Application no: **3/2021/1153**

Address: **land adjacent to no 9 Old Road Chatburn BB7 4AB**

Proposal: **Proposed dwelling with basement accommodation on an in-fill site adjacent to no 9 Old Road Chatburn, following refused applications 3/2019/0498 and 3/2020/0145.**

The Local Highway Authority have viewed the plans and highway related documents and have the following comments to make:

name **site plan as proposed** scale **1 to 100 @ A1** date **october 21** type **planning** revision **F**

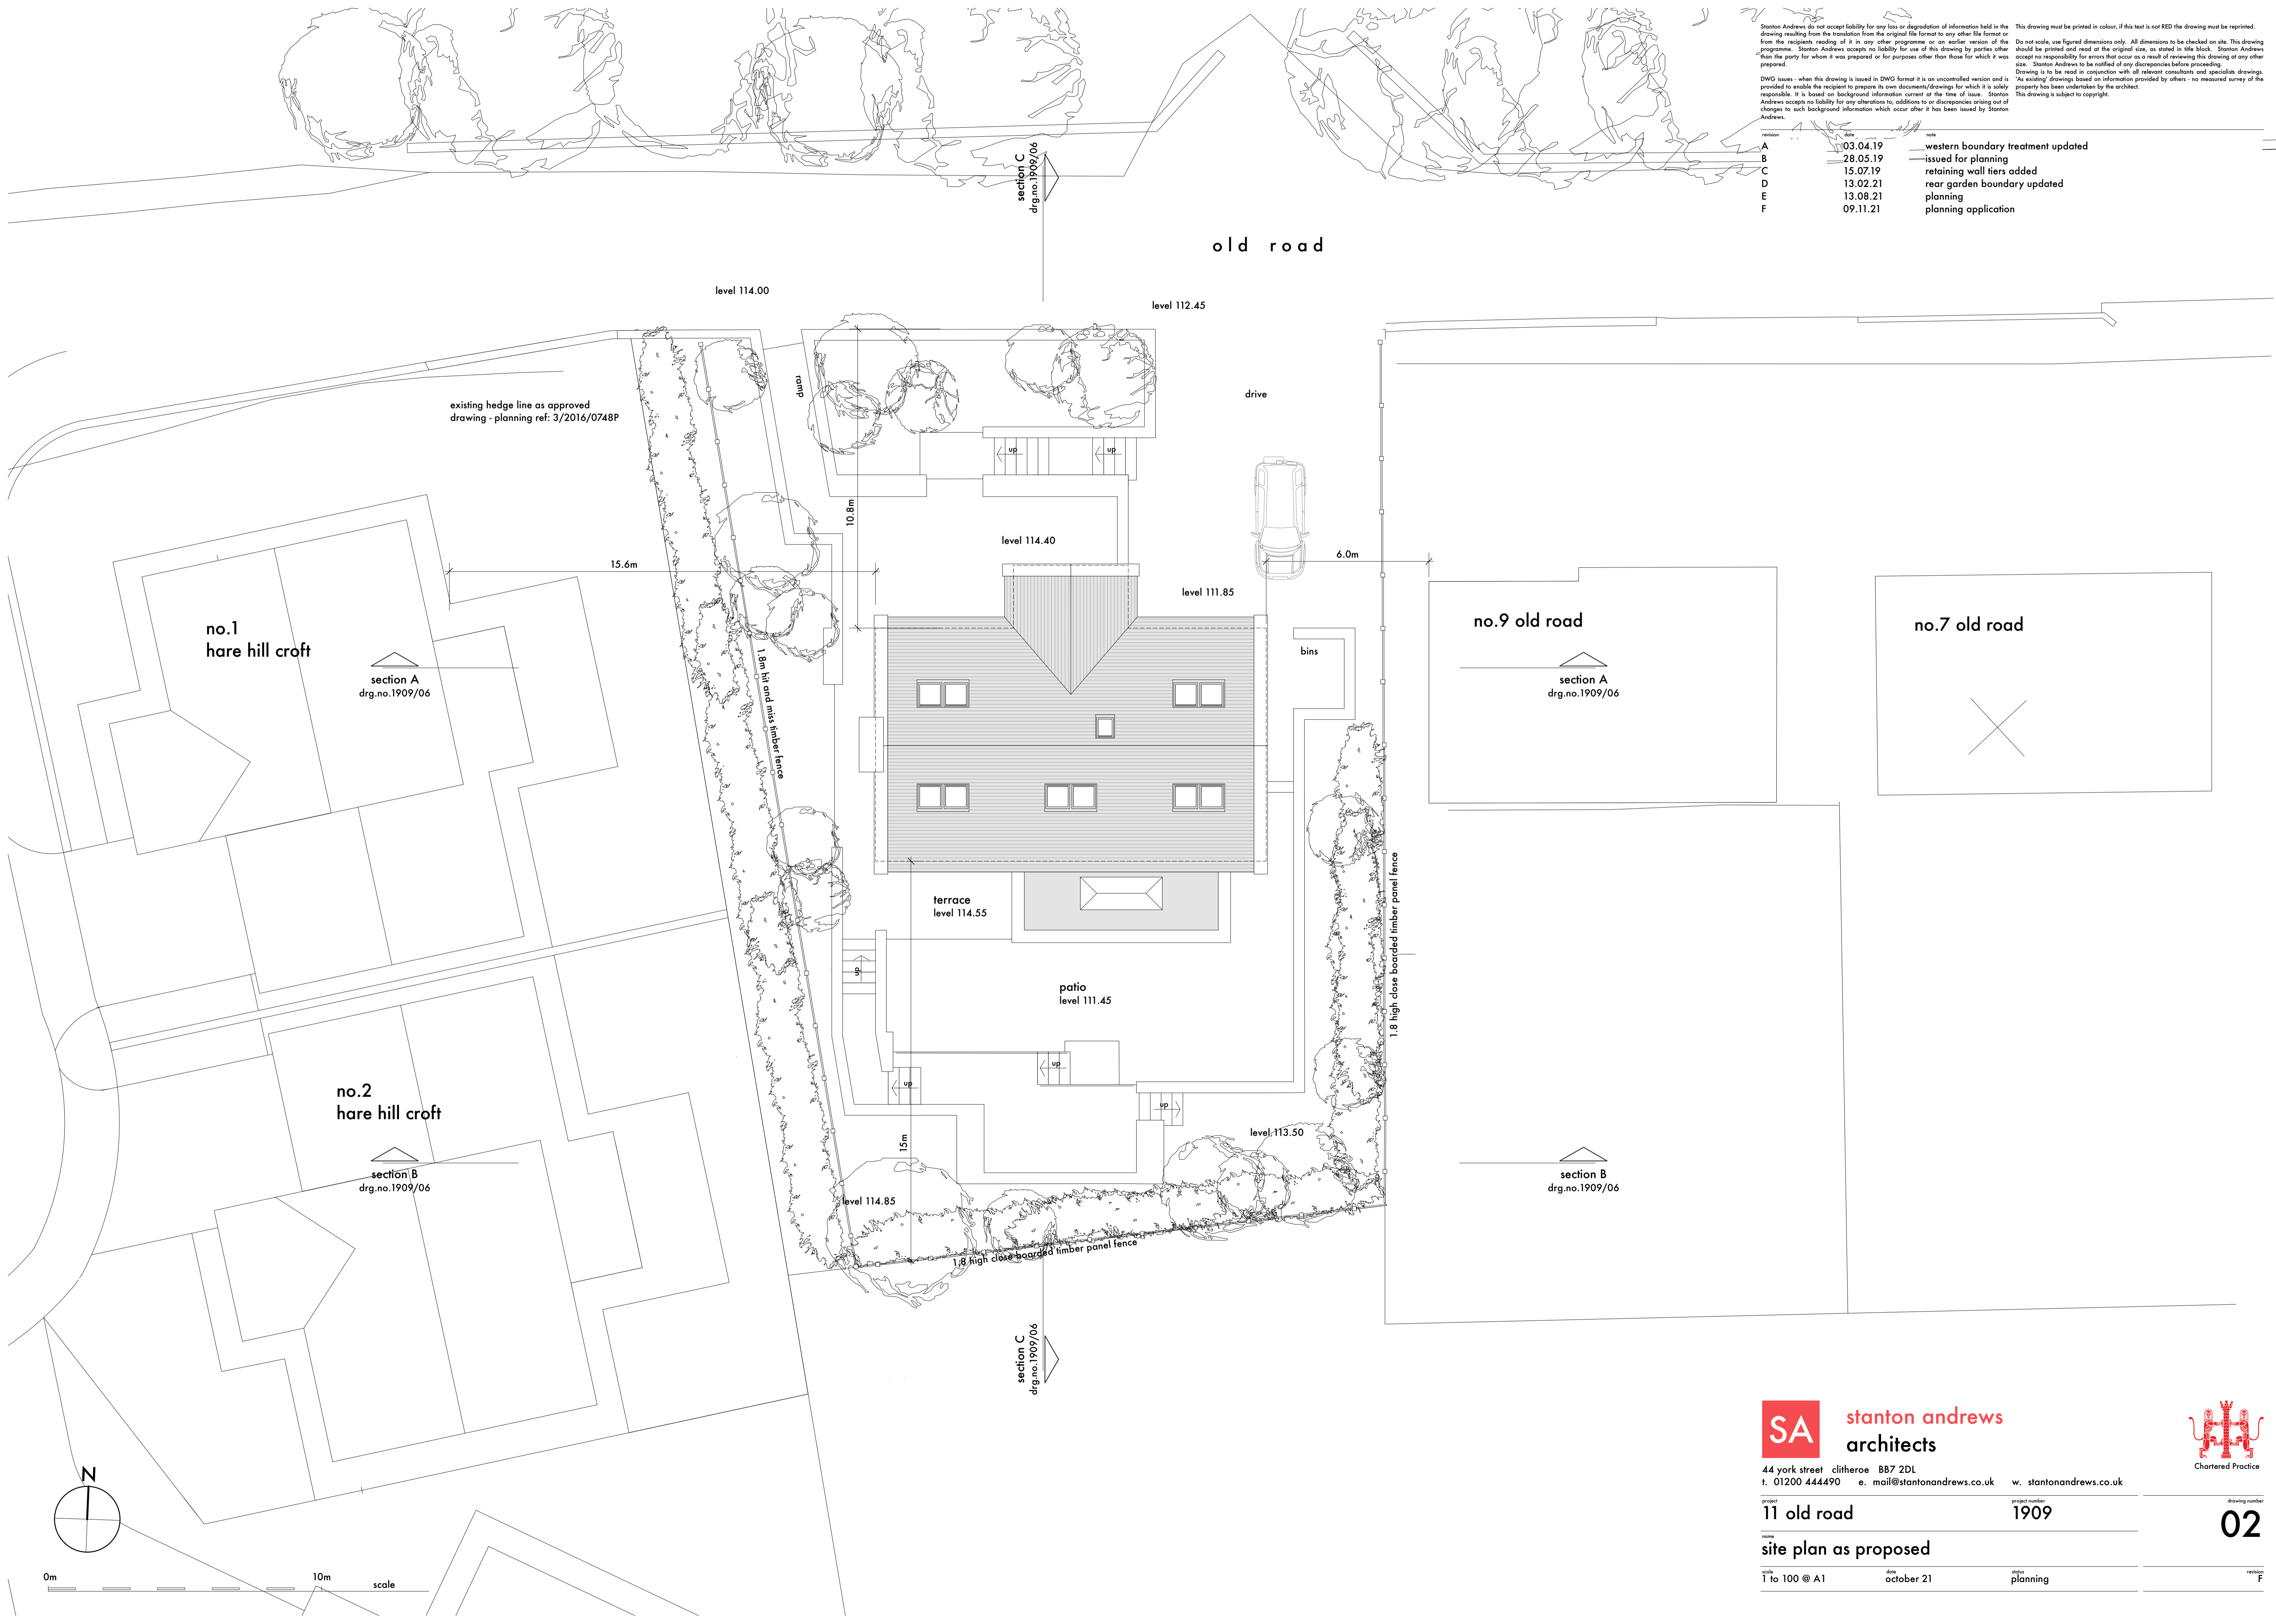
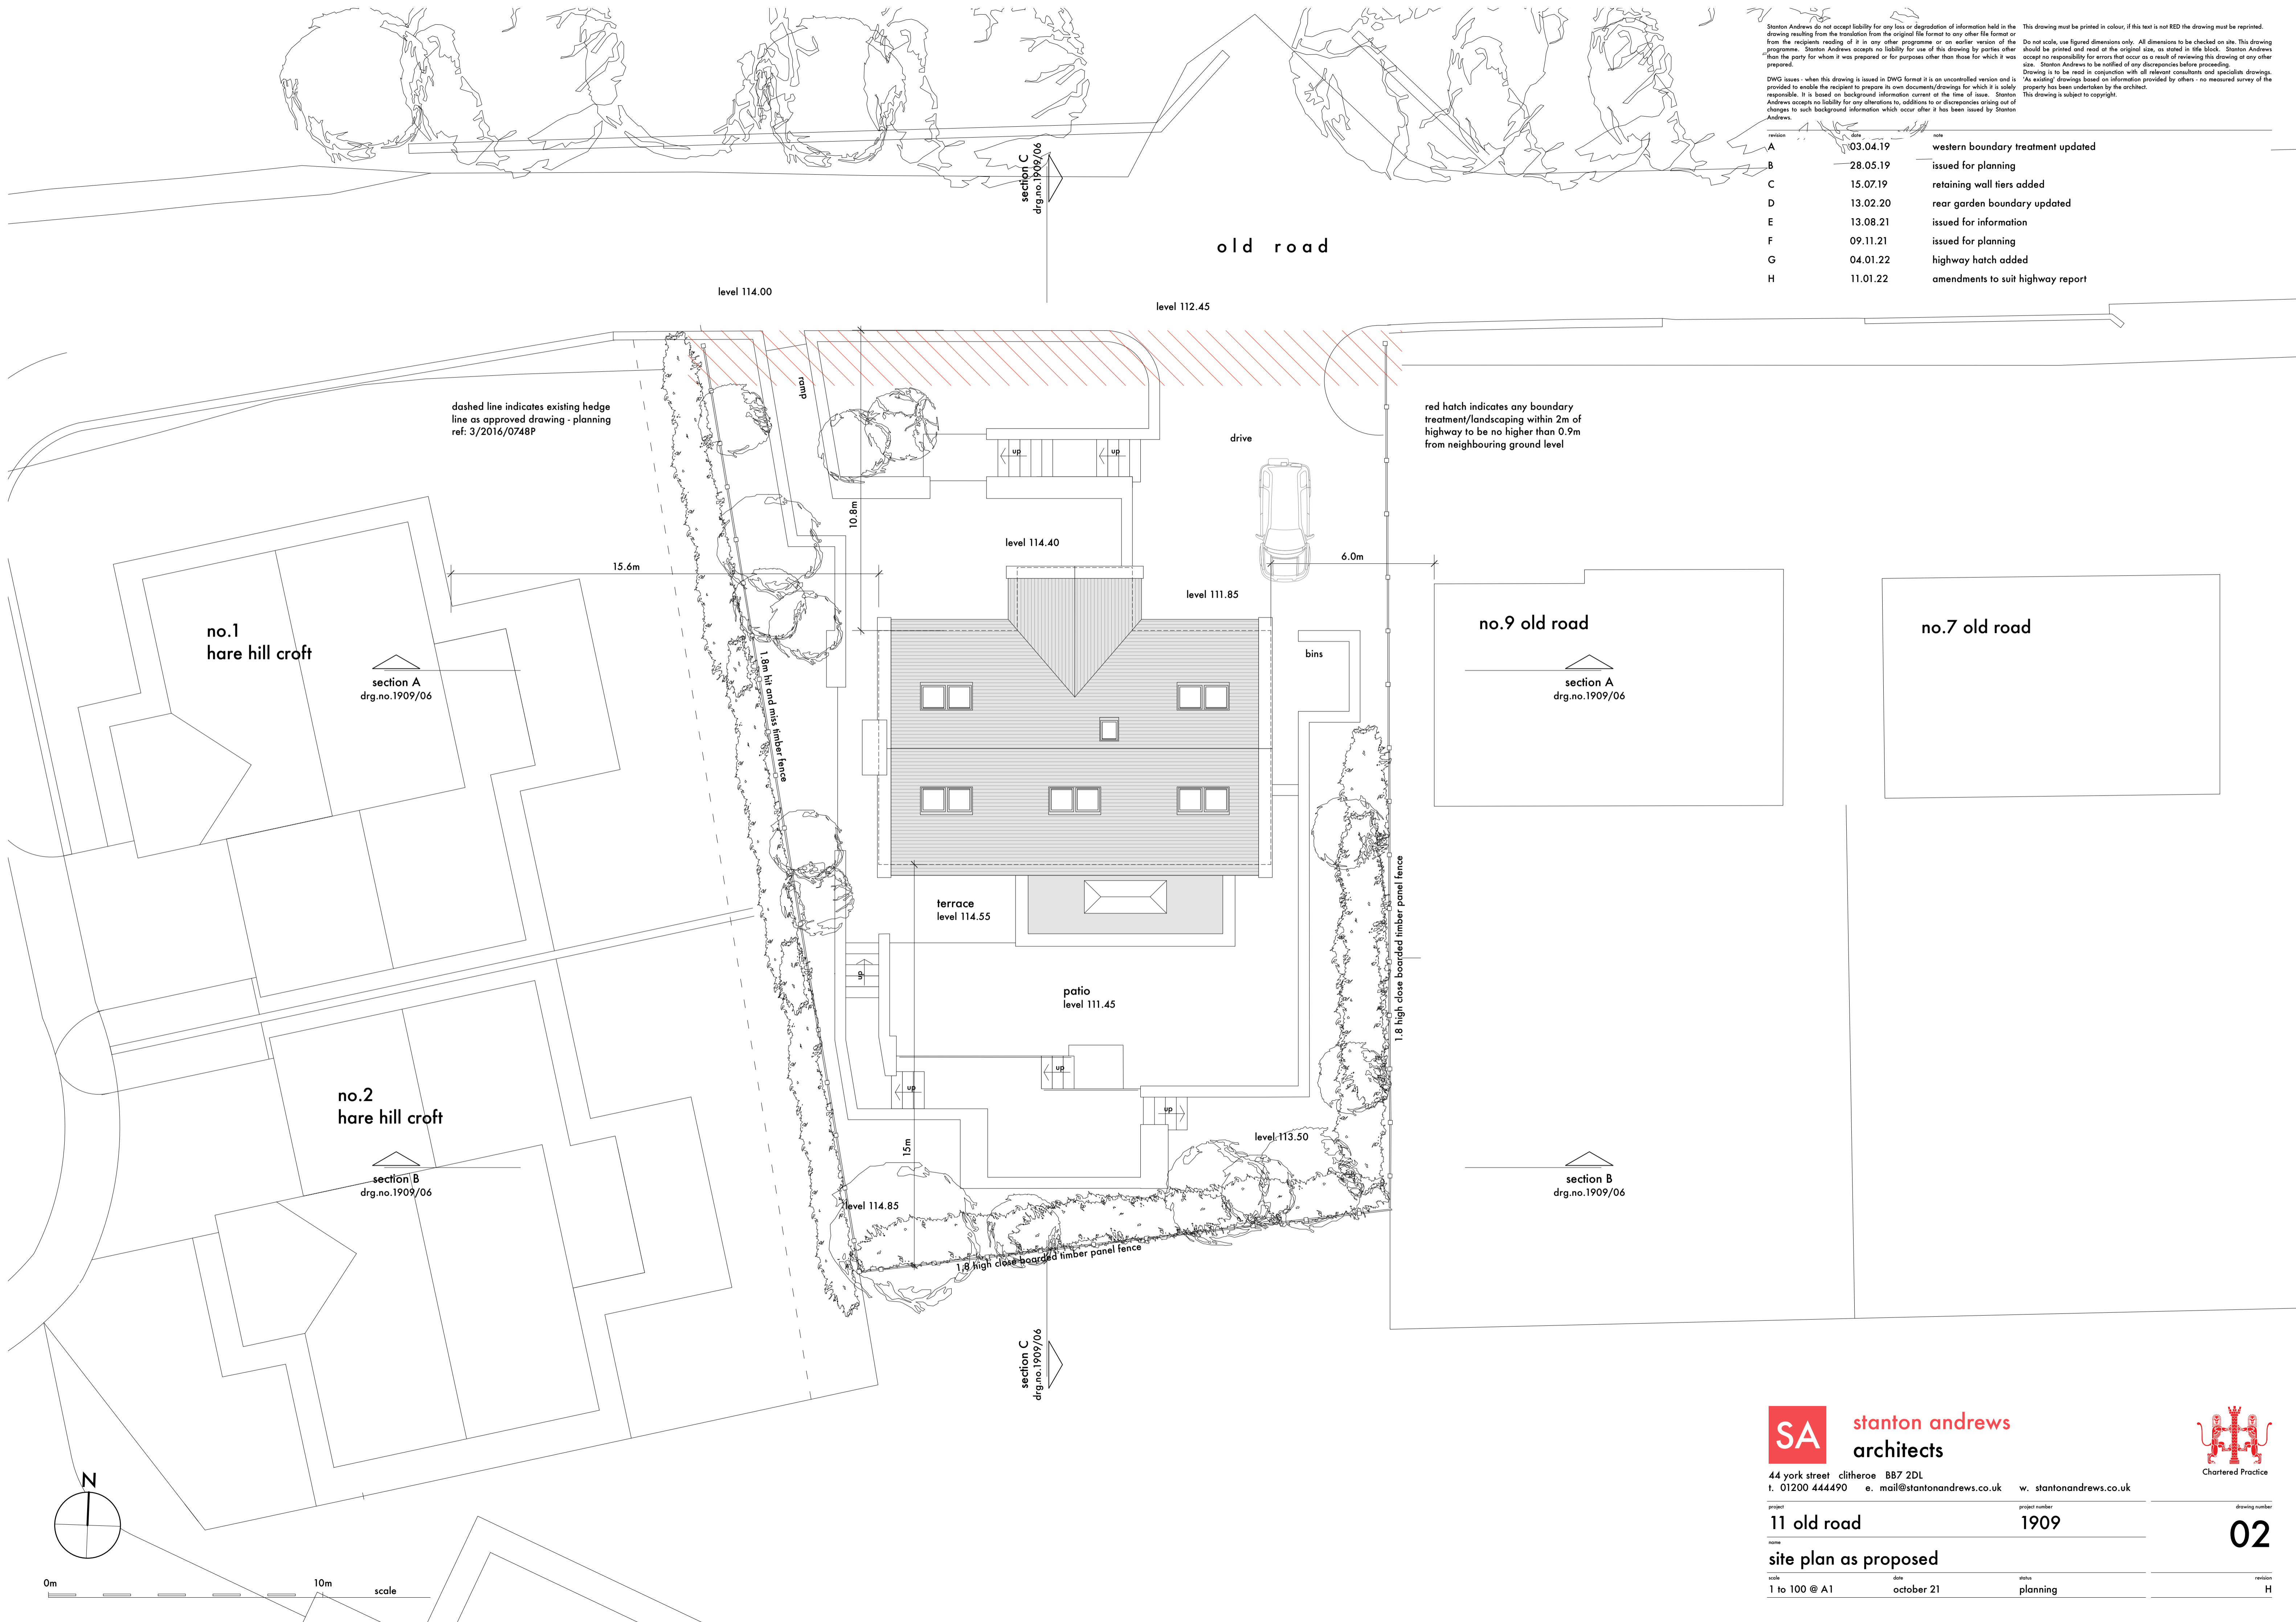
The LHA have reviewed the proposed access, as shown on Stanton Andrews drawing number 02 Rev F titled "Site Plan As Proposed" and are satisfied that the access arrangements complies with the LHAs guidance.

However, the LHA require a visibility splay drawing at the site access showing that the access can achieve the minimum vehicular visibility for a 30mph road, as defined in the LHAs guidance titled "Creating Civilised Streets."

In the LHAs guidance, the LHA require a new access directly off a 30mph road to achieve the minimum vehicular visibility of 2m x 43m in both directions. These should be shown on a revised drawing.

For the LHA to consider accepting the visibility splays below those identified in the guidance titled "Creating Civilised Streets," a speed survey demonstrating the 85th percentile speeds should be submitted.

Furthermore, the LHA have reviewed Stanton Andrews drawing number 02 Rev F titled "Site Plan As Proposed" and are aware that there will be a 1.8m high fence to the right of the access, separating the proposed dwelling and number 9 Old Road.

The LHA are aware that the 1.8m high fence will be located within the site's visibility splays. Therefore, the LHA remind the Agent that should a revised drawing showing the sites visibility splays be submitted and the LHA accept the drawing, the LHA will condition that anything within the splays is reduced to a height no higher than 0.9m to allow for vehicles to clearly view the public highway. This will include reducing the height of the fence.

The LHA have reviewed Stanton Andrews drawing number 02 Rev F titled "Site Plan As Proposed" and are satisfied that the parking arrangements complies with the LHAs guidance as defined in the Joint Lancashire Structure Plan. Therefore, the LHA have no further comments to make regarding parking.
